**Development
Application
Permit
Review**

PARKS AND COMMUNITY SERVICES DEPARTMENT

Name:	Mayberry Filing No.5	Application Type:	PUDSP
PCD Reference #:	PUDSP233	Total Acreage:	8.31
Applicant / Owner:	Owner's Representative:	Total # of Dwelling Units:	146
Mayberry Communities	Kimley-Horn & Associates	Dwelling Units Per 2.5 Acres:	43.92
Scott Sauder	Larry Salazar	Regional Park Area:	4
32823 Temecula Parkway	2. North Nevada Ave, Suite 900	Urban Park Area:	5
Temecula, CA 92592	Colorado Springs, CO 80903	Existing Zoning Code:	PUD
		Proposed Zoning Code:	PUD

Agenda Item Title: Mayberry Filing No. 5 Preliminary Plan

PLANNED UNIT DEVELOPMENT & PRELIMINARY PLAN
A PORTION OF MAYBERRY, COLORADO SPRINGS, FILING NO. 1A

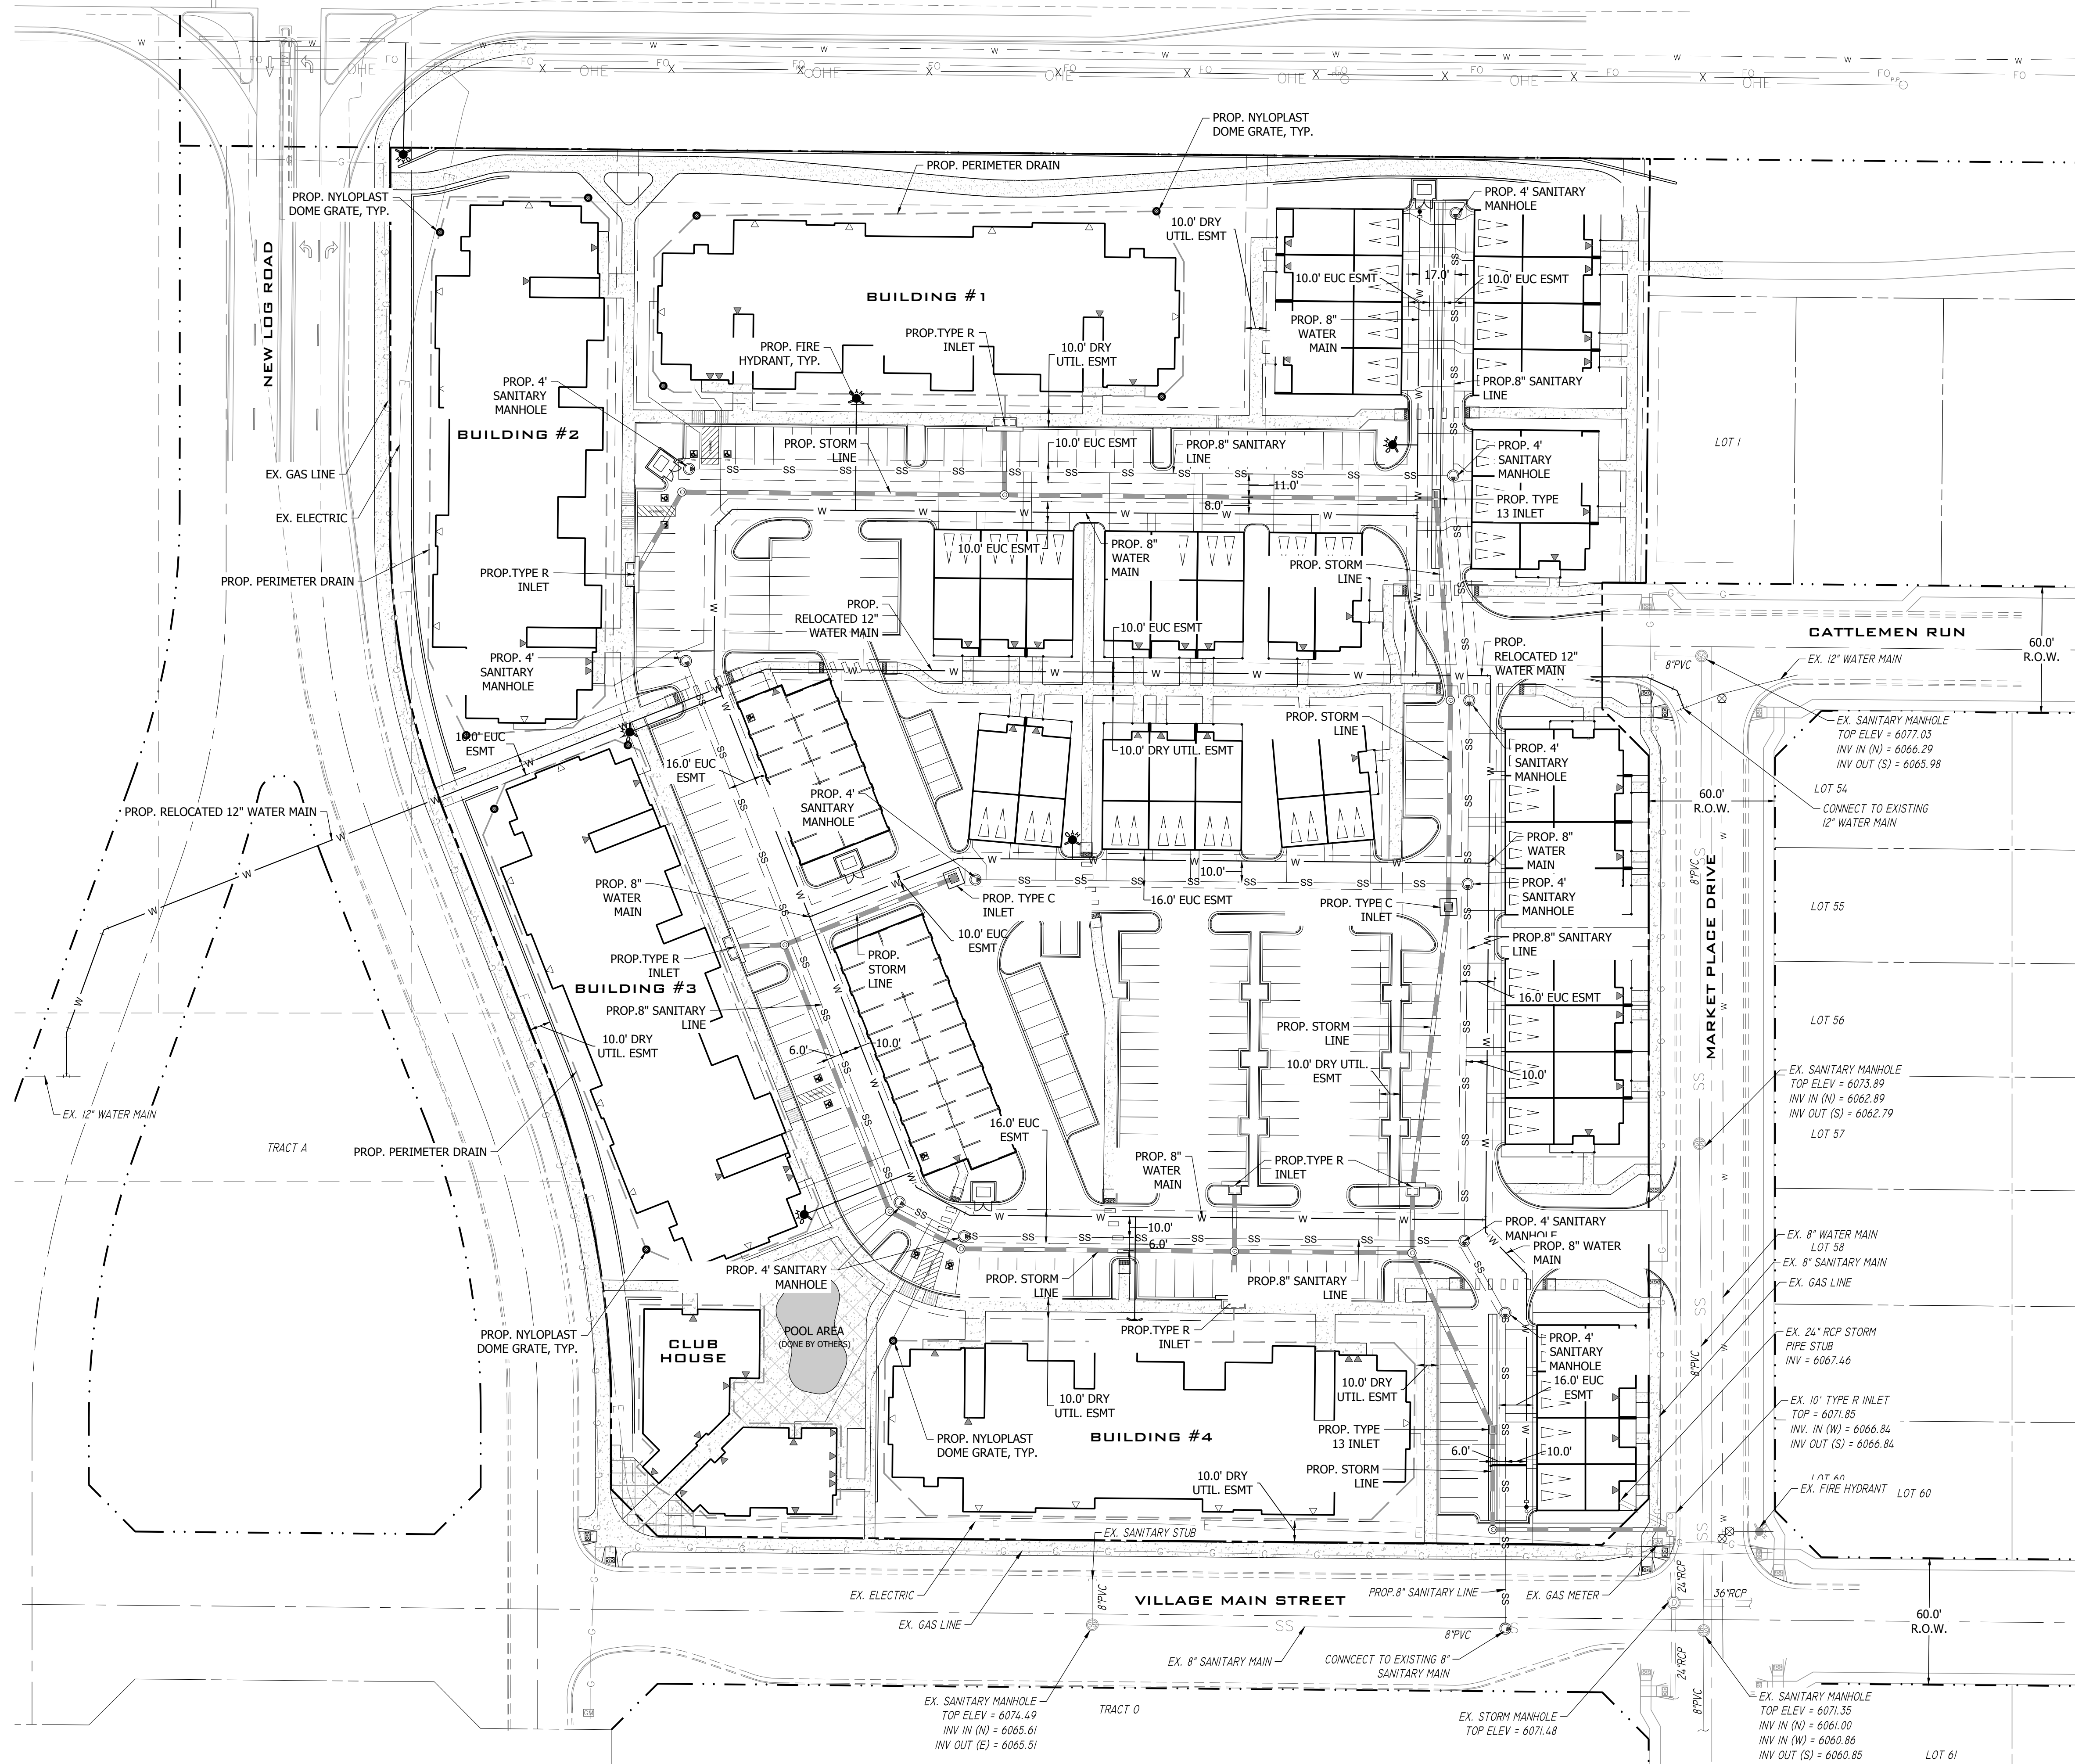
Per the El Paso County Land Development Code, (LDC) a Planned Unit Development (PUD) is required to have 10% open space. The open space is calculated from the gross site area as shown on the development's sketch plan. Mayberry Filing No.5 shows 2.38 acres of open space or 29% of the total 8.3 acre site. This exceeds the 10% open space requirement and conforms to the sketch plan. However, it is unclear exactly what areas are being counted as open space. The sketch plan shows a trail on the north side of the site, a clubhouse on the SW side, and landscape setbacks around the buildings. A detailed breakdown of the open space would be helpful to evaluate the open space requirement.

Mayberry Filing 5 shows an 8' sidewalk south of Highway 94 along the north property line of the site. The proposed 8' wide sidewalk would be an acceptable alignment for the Highway 94 Regional Trail, provided it has connections at the east and west end of the site to the future Highway 94 Regional Trail. According to the plan, the 8' wide sidewalk ends at the apartment buildings on the east end of the site and tees into an internal sidewalk. The 8' wide sidewalk shall be shown to connect to the future Highway 94

Regional Trail alignment to the east instead. At the west end of the project, the 8' wide sidewalk is shown ending at Mayberry Drive and teeing into a 7' wide internal north-south sidewalk. A tree is shown west of this intersection. Instead, the Highway 94 Regional Trail should be shown with a future connection to the west of Mayberry Drive with a crosswalk at the intersection.

County Parks requests trail easements where development projects impact proposed County trails. As it pertains to this application, the County requests that the landowner provide a 25-foot public trail easement along the south side of Highway 94 that allows for the construction and maintenance by El Paso County of the Highway 94 Primary Regional Trail, and this easement shall be shown and dedicated to El Paso County on the Final Plat.
